Applicant: James White (White Home)
Owner: Jaffy Gurd
Address: 17 Basket Lane

C-B-L: 390-A-22
permit # 2014-01425

CHECK-LIST AGAINST ZONING ORDINANCE

Proposed Use/Work - build two story single family home w/ attached garage

**SITE PLAN**  
 OF:  
 LOT 22 - RIVERWALK SUBDIVISION  
 BASKET LANE, PORTLAND, MAINE  
 FOR:  
 ESTELLE GOULD REVOCABLE TRUST  
 JOYTAFFY GOULD  
 10 EDGEWATER DRIVE #14  
 CORAL GABLES, FLORIDA 33133

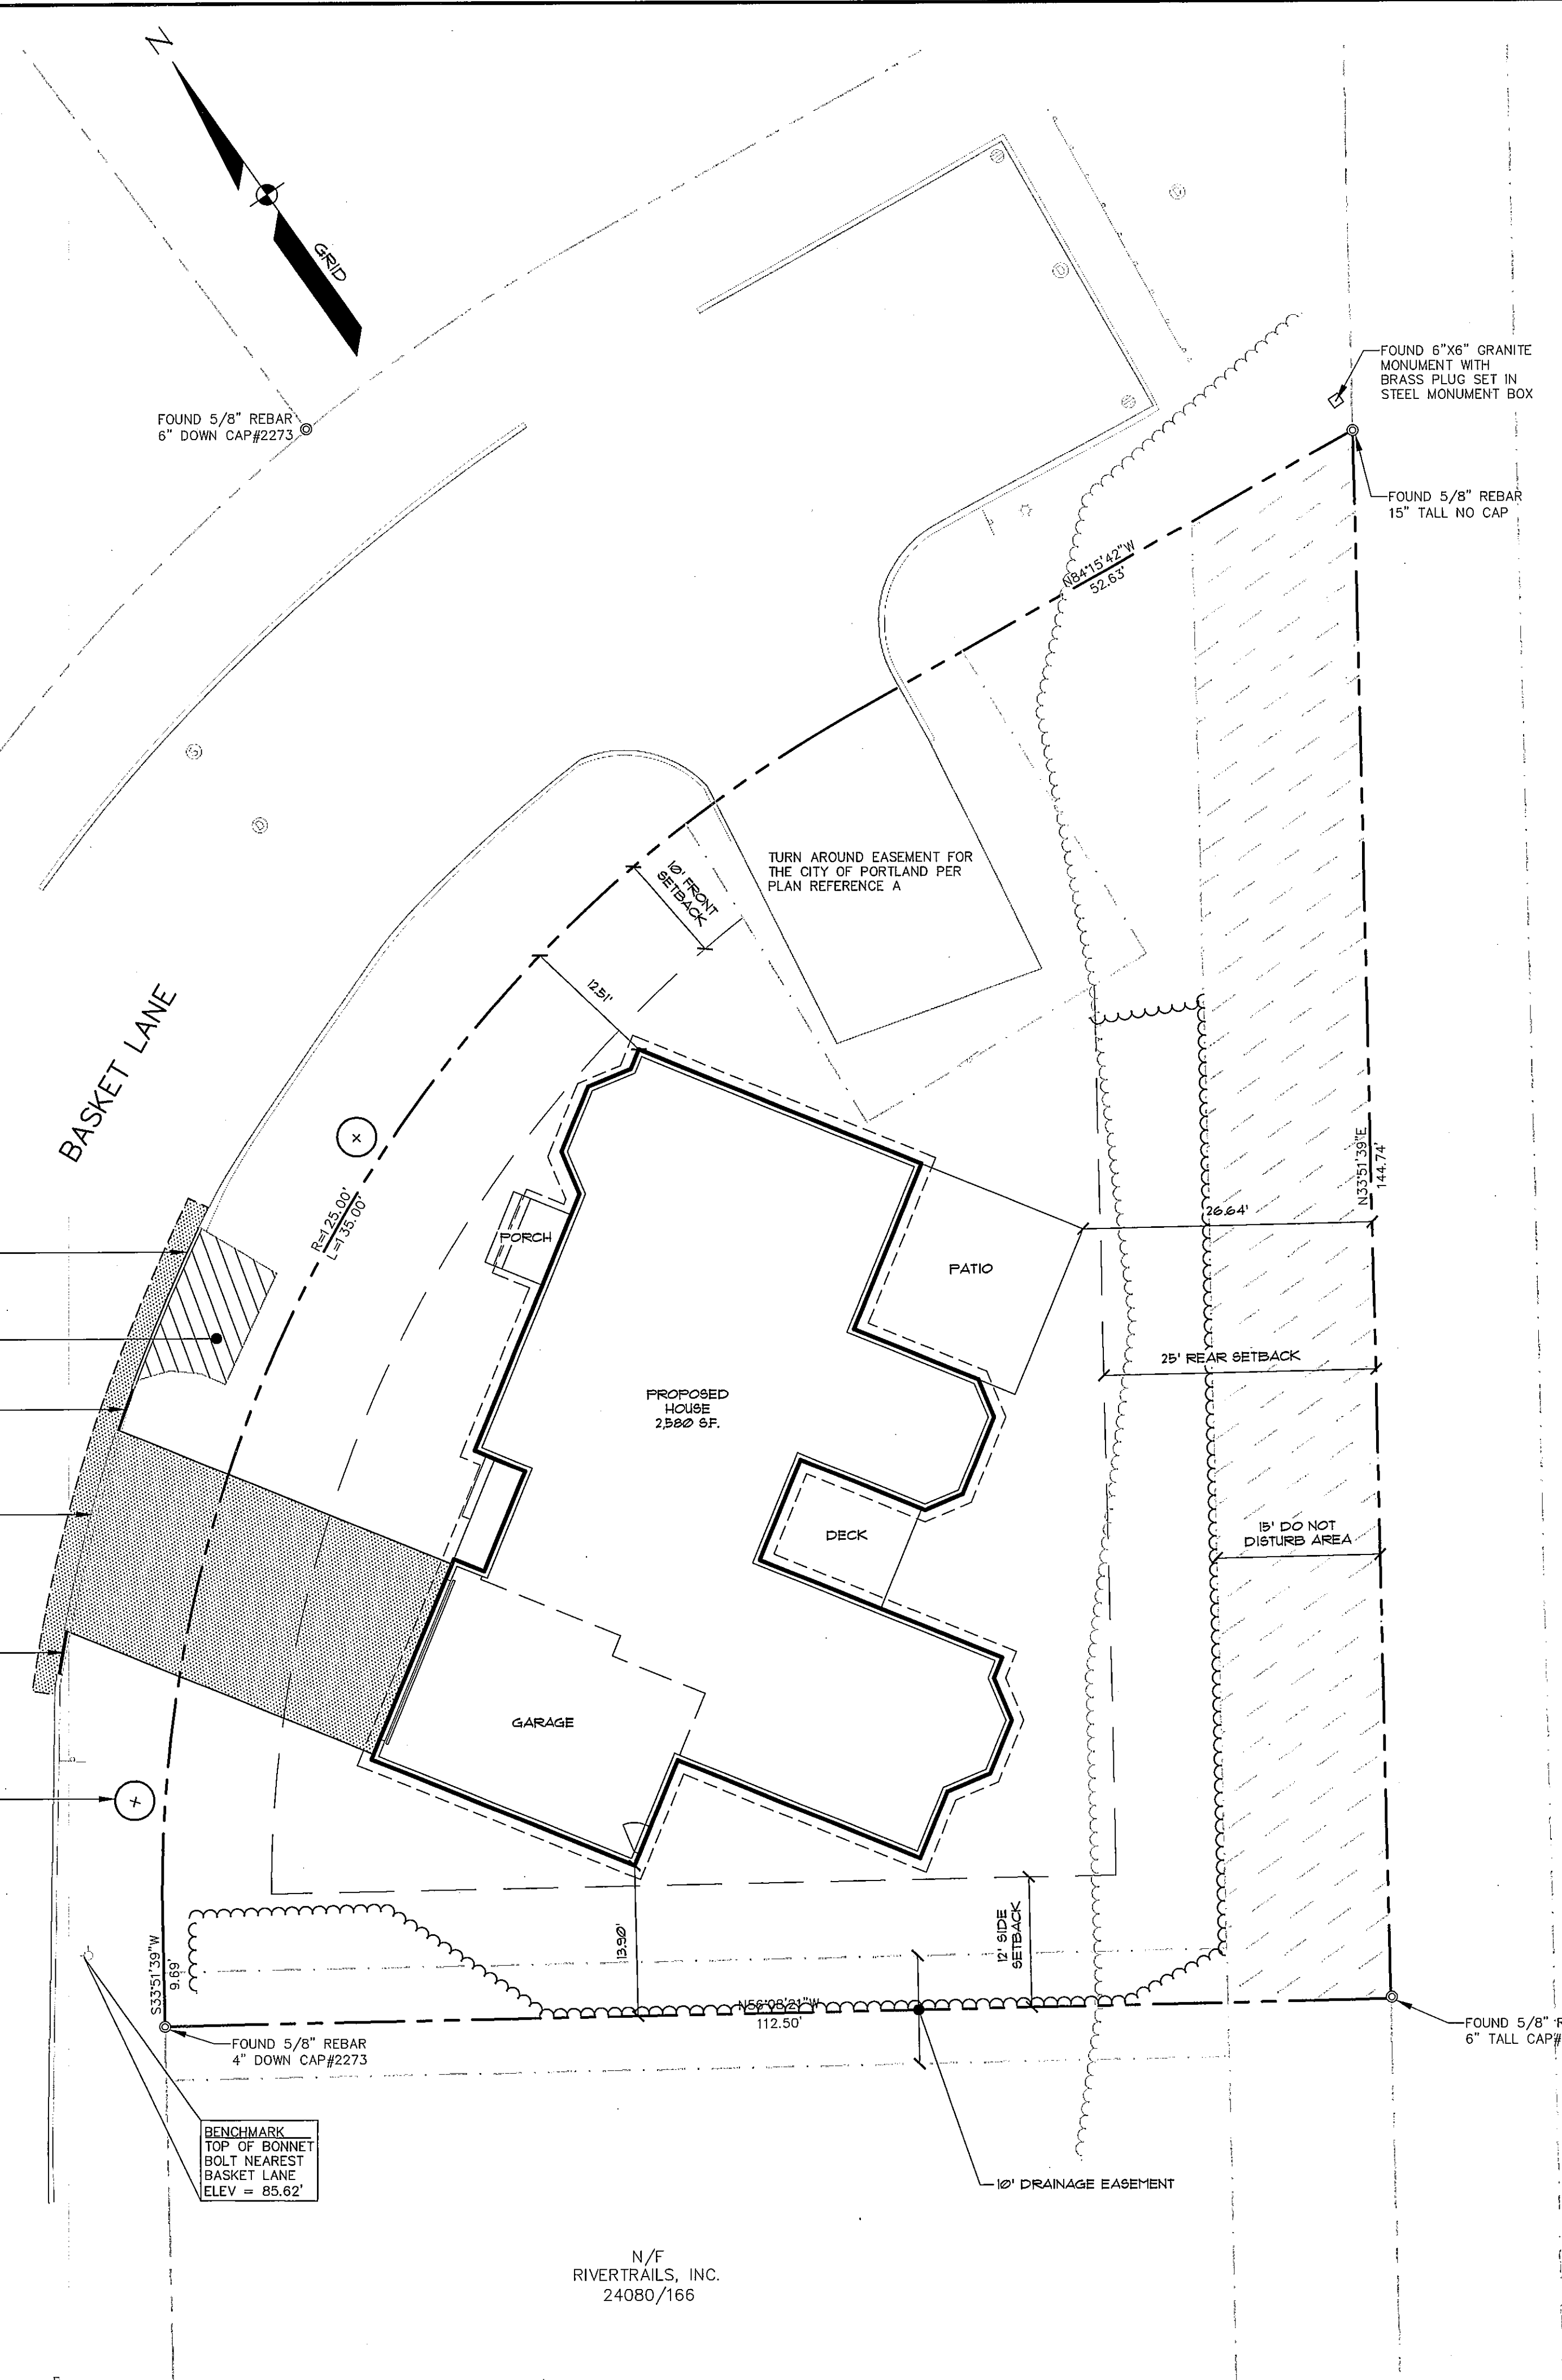
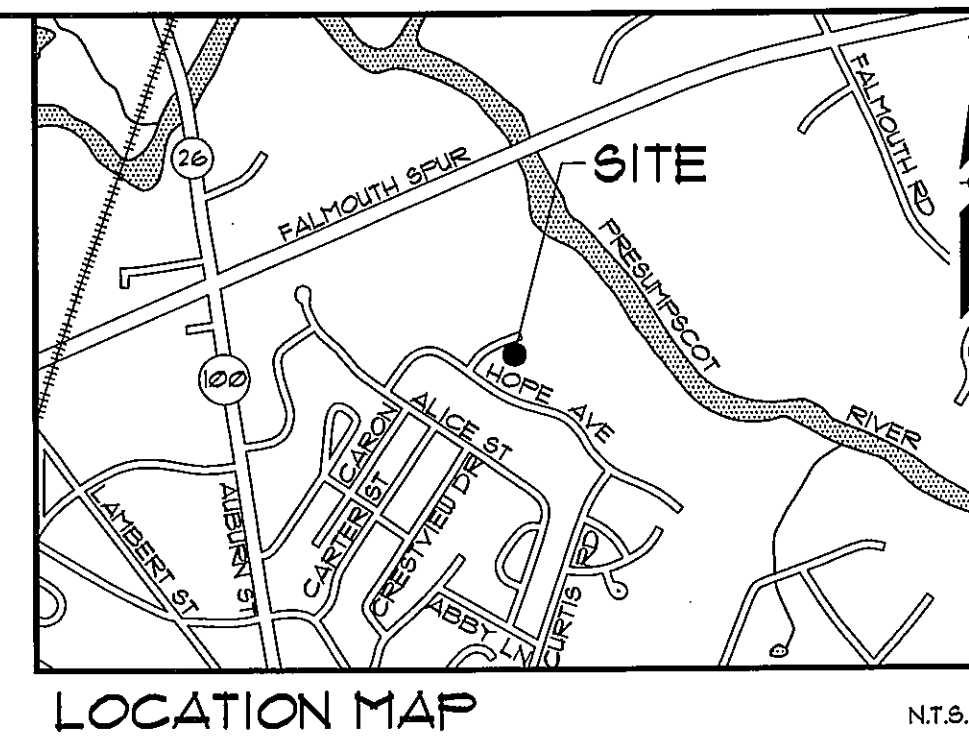
Lot Street Frontage - 50' min - $9.69' + 135' + 52.63' = 197.32$ (see survey) (OK)

Front Yard - 10' min - 11.3' scaled (OK)

Rear Yard - 20' min - 39.2' scaled from closest point

Side Yard - 12' min / same for side yard on side street - on left - 15.2' scaled (OK)
- on right - 26.7' scaled (OK)

Height - 35' max - 33' scaled from lowest side (OK)

Lot Area - 6,000 ϕ min - 11,973 ϕ given (OK)

Off-street Parking - 2 spaces - one in garage - one beyond setback
